Engineers Comments Regarding Surface Water Drainage

Application Reference:	CM/18/25/DOC	Reviewer Reference:	ADC/EXT12/GK
Planning Officer:	Jessica Riches	Date of Review:	06/08/2025
Site Name:	Land West of Church Lane & South of Horsemere Green Lane Climping		
Application Description:	Approval of details reserved by condition imposed under reference CM/1/17/OUT relating to condition number 9 - i. surface water drainage scheme and ii. a foul water drainage scheme and condition number 10 - i./ ii. watercourses and iii. rising main and foul sewer pipe.		
Assessment Number:	1 of 2

NoApplication Reference: CM/18/25/DOC Site Name: Land to the West of Church Lane and South of Horsemere Green Lane Climping	Initial Issue Date: Issue Date: 02/0102024 Reviewer Reference: ADC/EXT12/GK
--	--

Drawing file: CM_18_25_DOC / D2385 C410 - Section 104 Drainage Construction Details.pdf

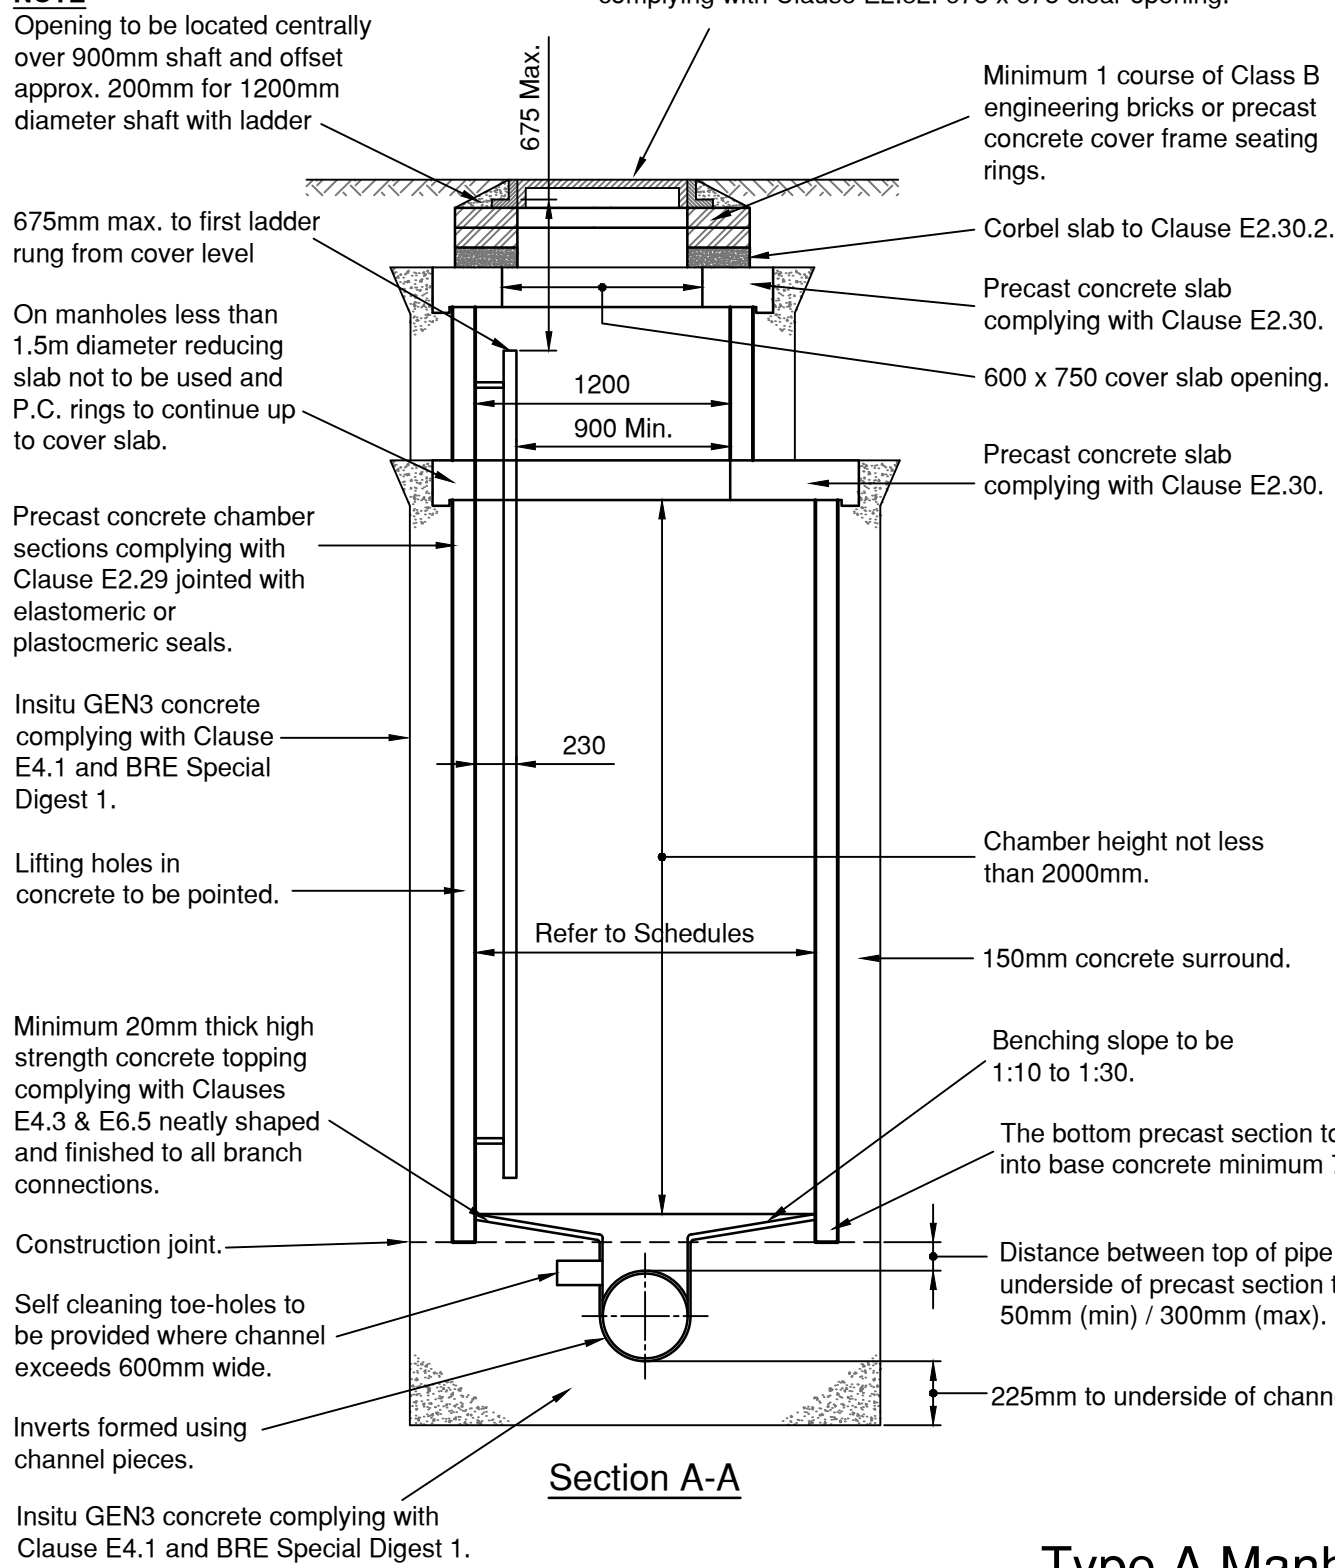
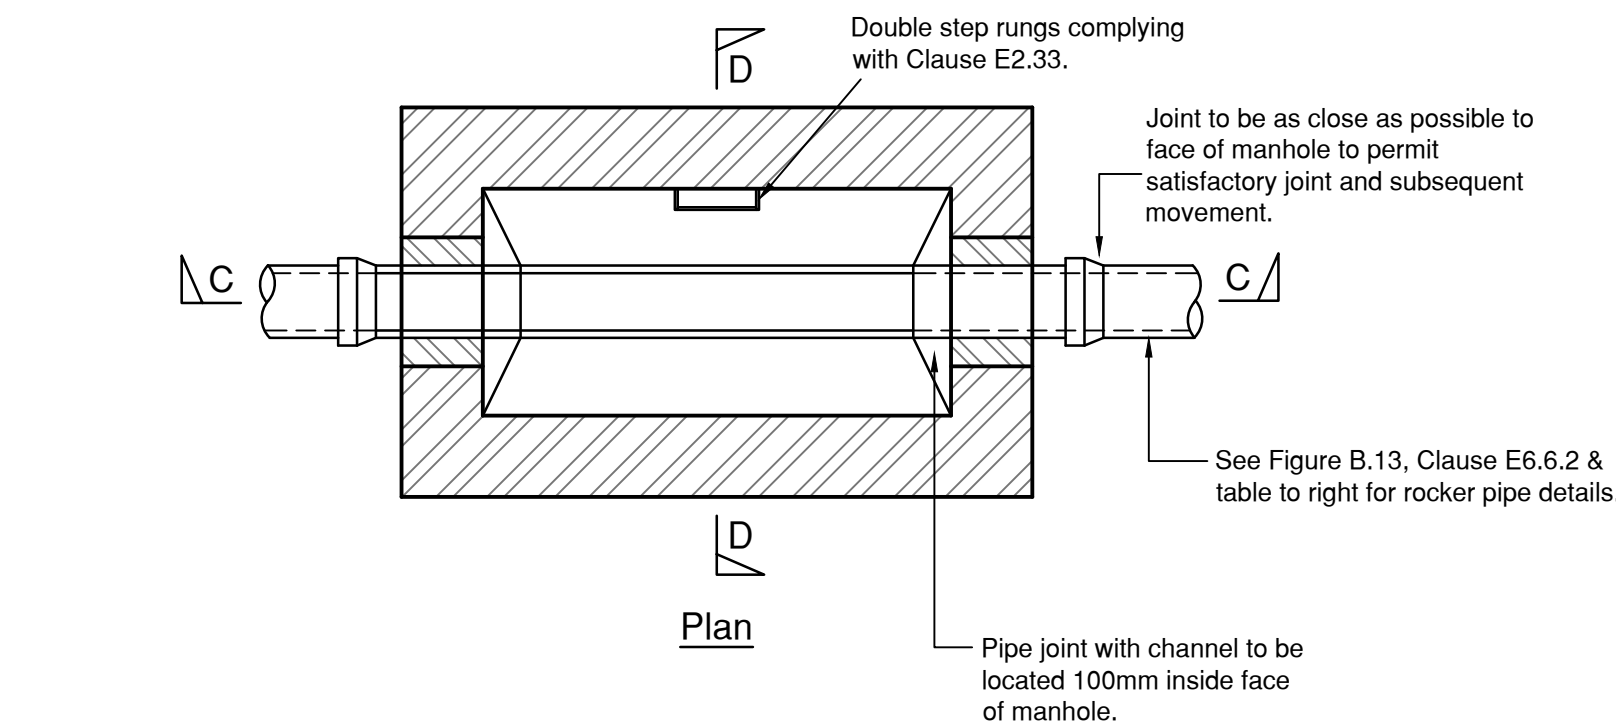
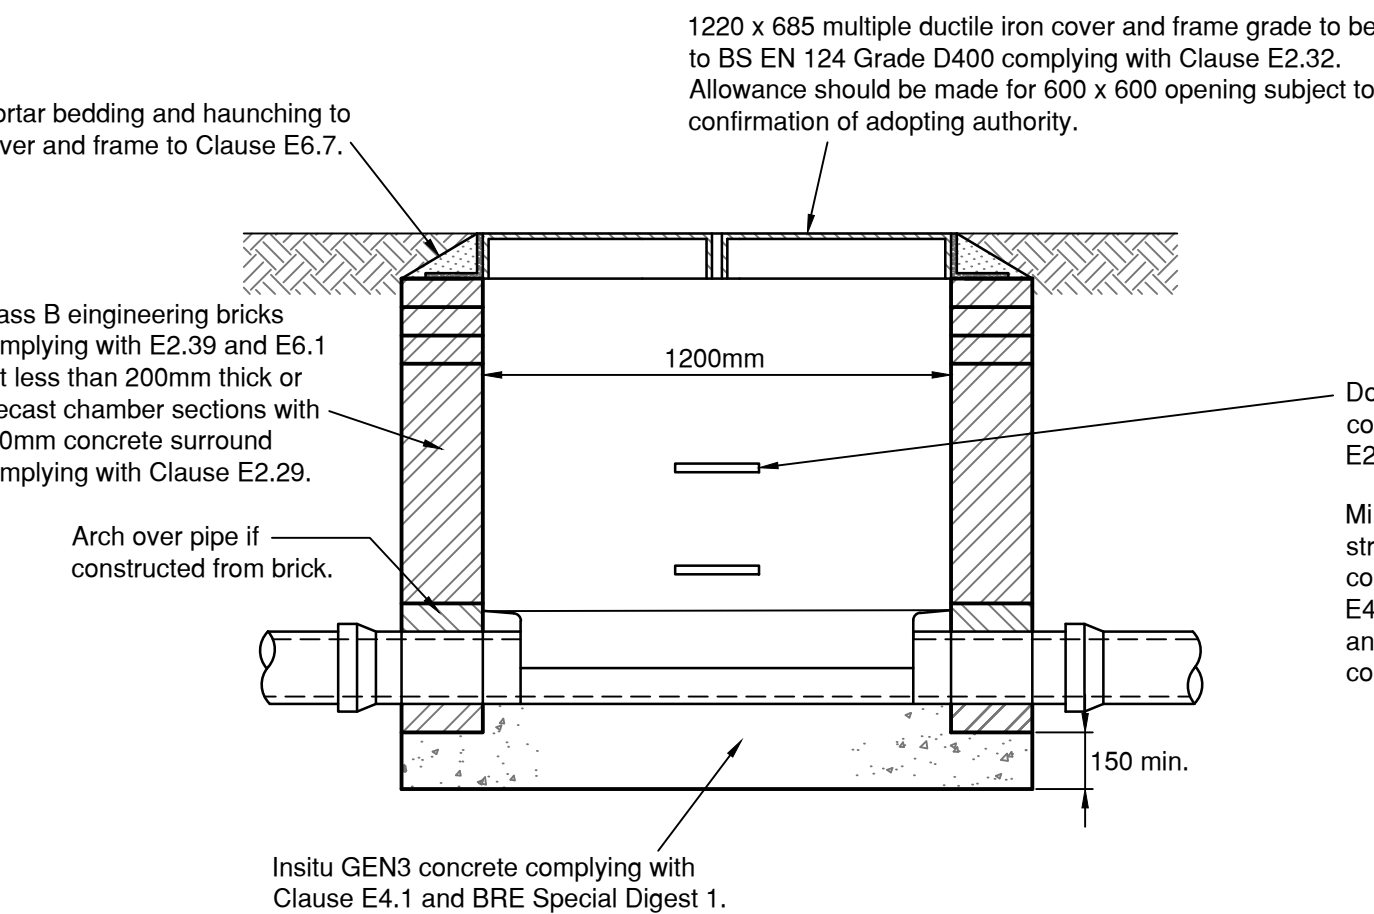
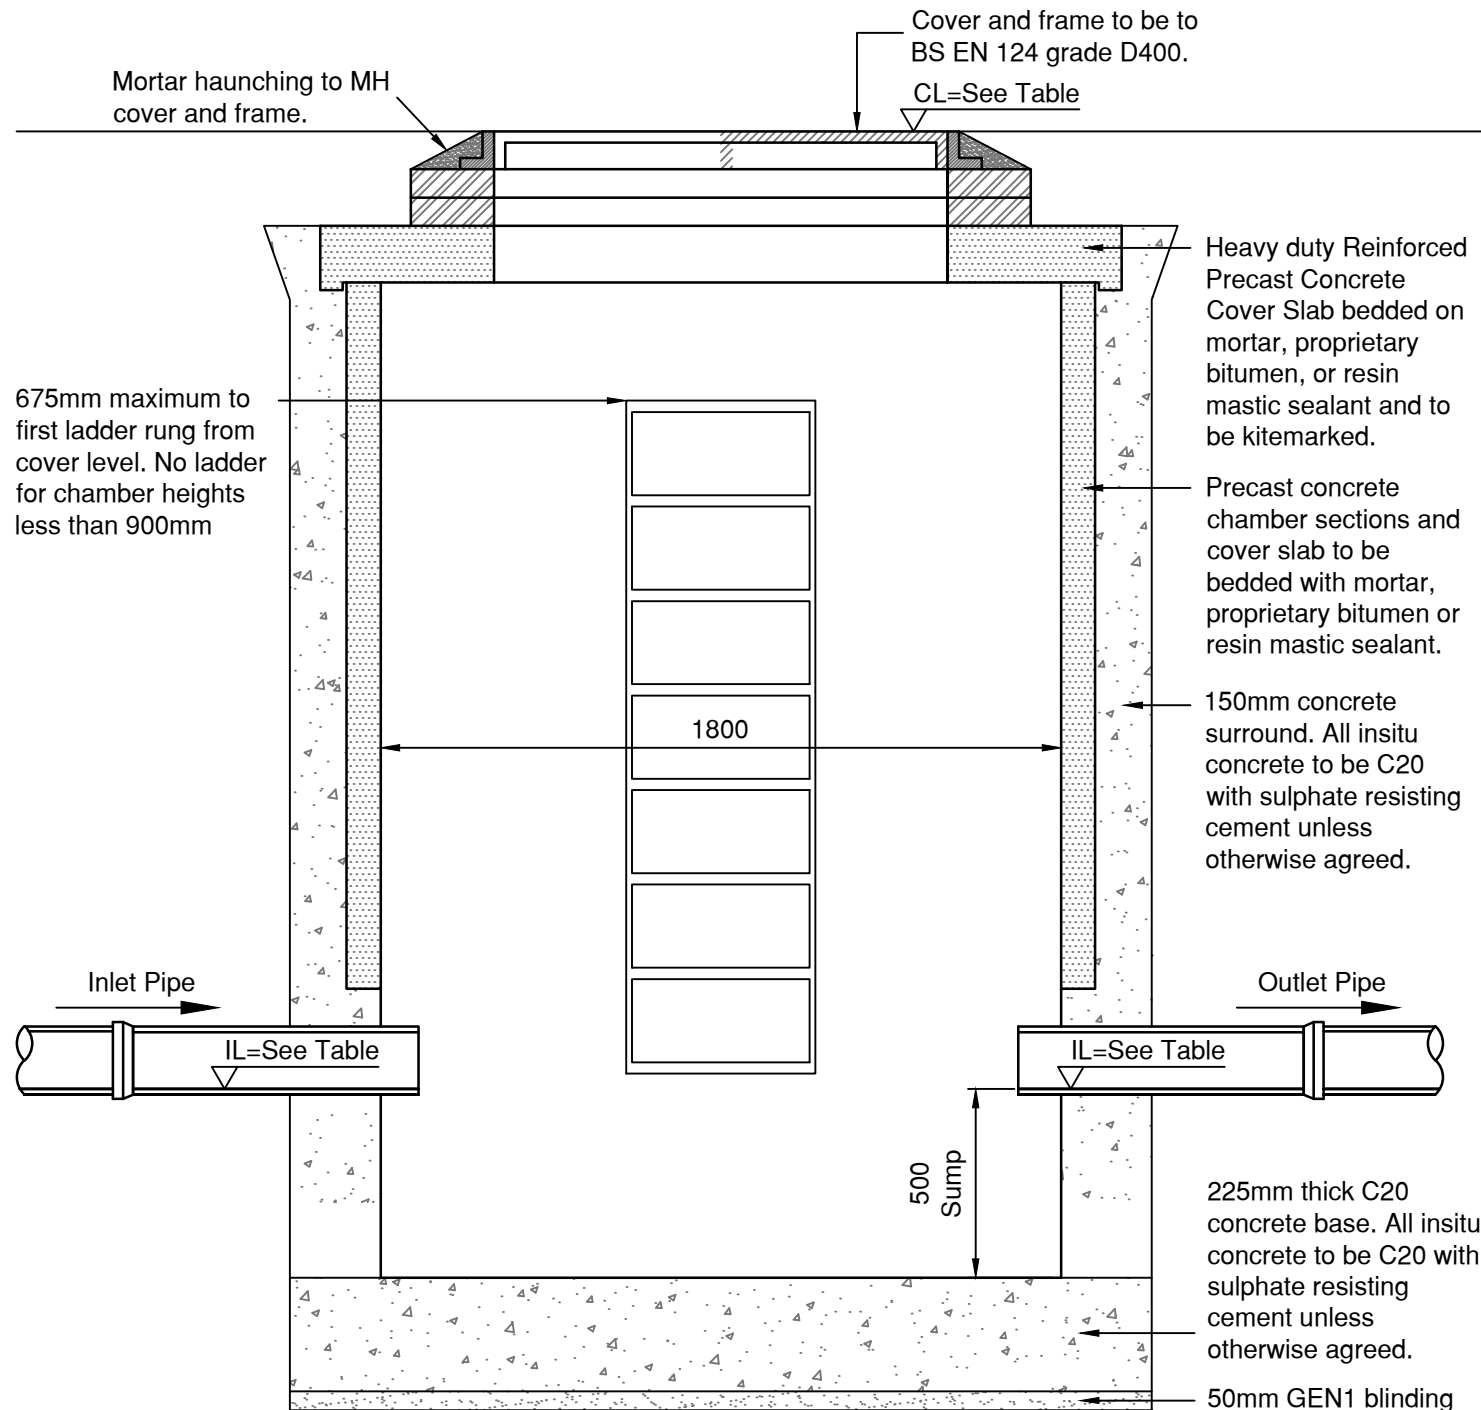
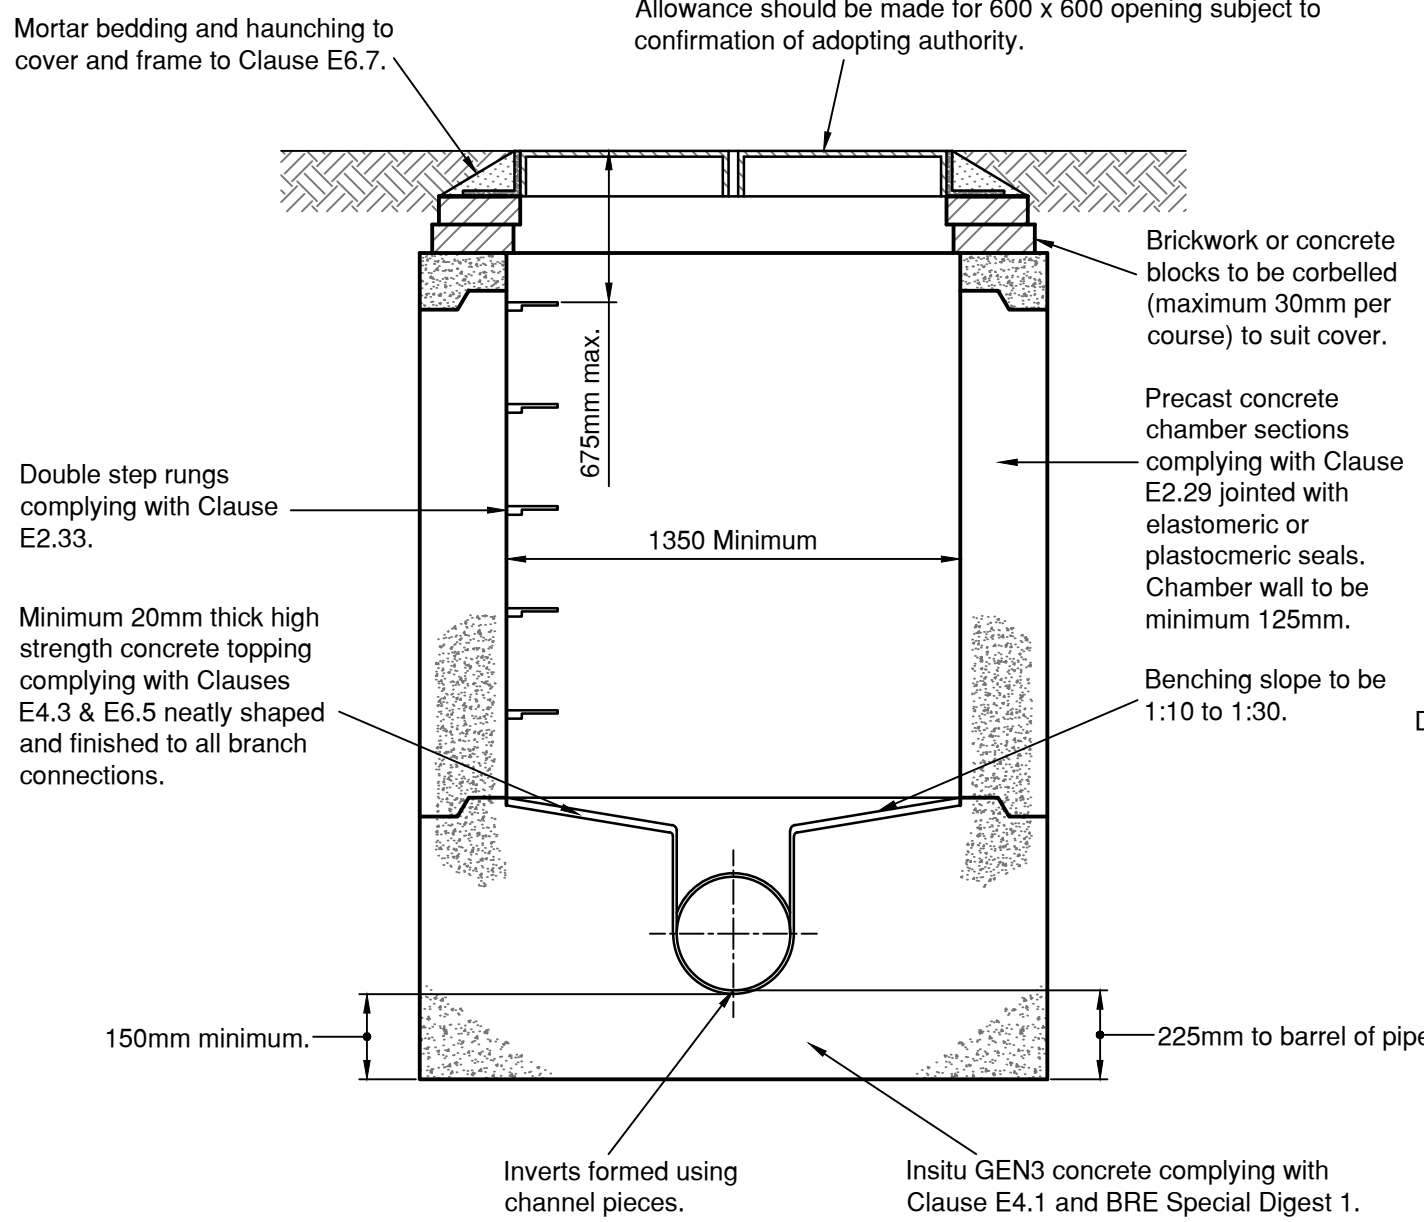
9.	No manhole schedules have been provided.	No comments – refer to updated design.	Manhole schedule submitted but many manholes are missing probably due to wrong printing options. All the manholes are shown as Type E which is impossible. Please also note which manholes are catchpits. All the manholes have a diameter of 450 which is wrong in many cases. Please amend. Please specify the cover type on manhole schedule. Clarify how the shallow pipes will be protected.	A 10% urban creep allowance has been applied to all plots. Please refer to the impermeable areas plans included with the response pack - FOR-E5139-489 to 491.	All the manholes prior to attenuation tanks and the watercourses should be catchpits. Please also specify the cover type of each manhole.
